From: Josh Pozzobon <josh@builtprefab.com>
Sent: Tuesday, October 7, 2025 8:56 AM
To: Geoffrey Gray
Cc: Ellie Myers; Ian Garrity; Jamey Ayling
Subject: Re: CARA Referral
Attachments: 1578002 SITE PLAN R1.pdf

Subject: RE: CARA Referral

Planner I | **Kittitas County Community Development Services**

SITE PLAN - NEIGHBORING PROPERTIES

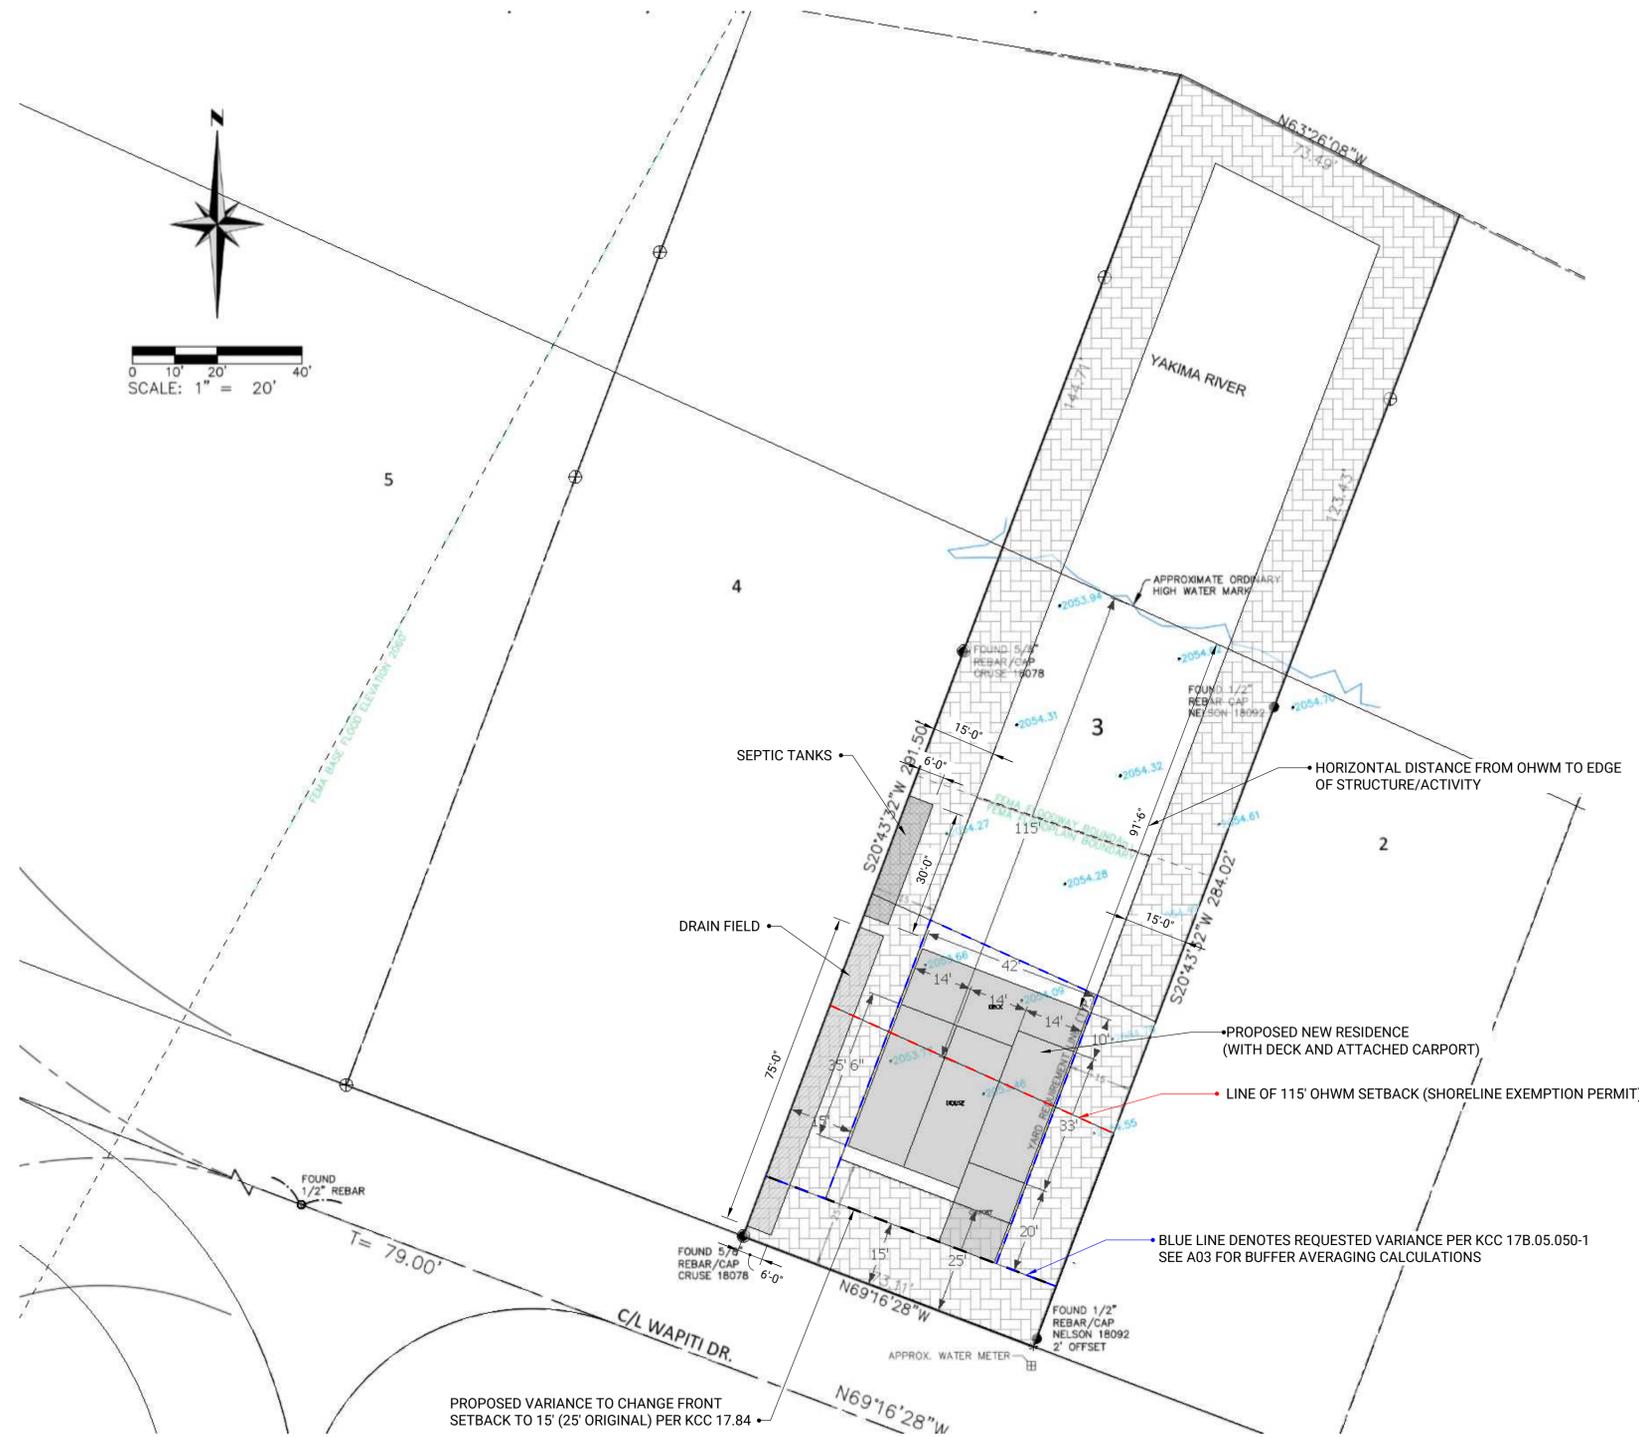
When you say "we are comfortable proceeding with the idea of establishing a 115-foot buffer and setback on the eastern property line", does that mean having the whole eastern property line as a non buildable area (shoreline buffer) like we had shown on our most recent site plan? Or are you meaning something different.

When we refer to "establishing a 115-foot buffer and setback on the eastern property," we are not designating the entire eastern property line of 1151 Wapiti Dr as a non-buildable shoreline buffer.

Instead, we are using the 115-foot measurement from the ordinary high water mark (OHWM) of the *eastern property* to establish a theoretical boundary for the purposes of applying the *common line setback* approach. This line helps define the setback for the proposed development on the subject property.
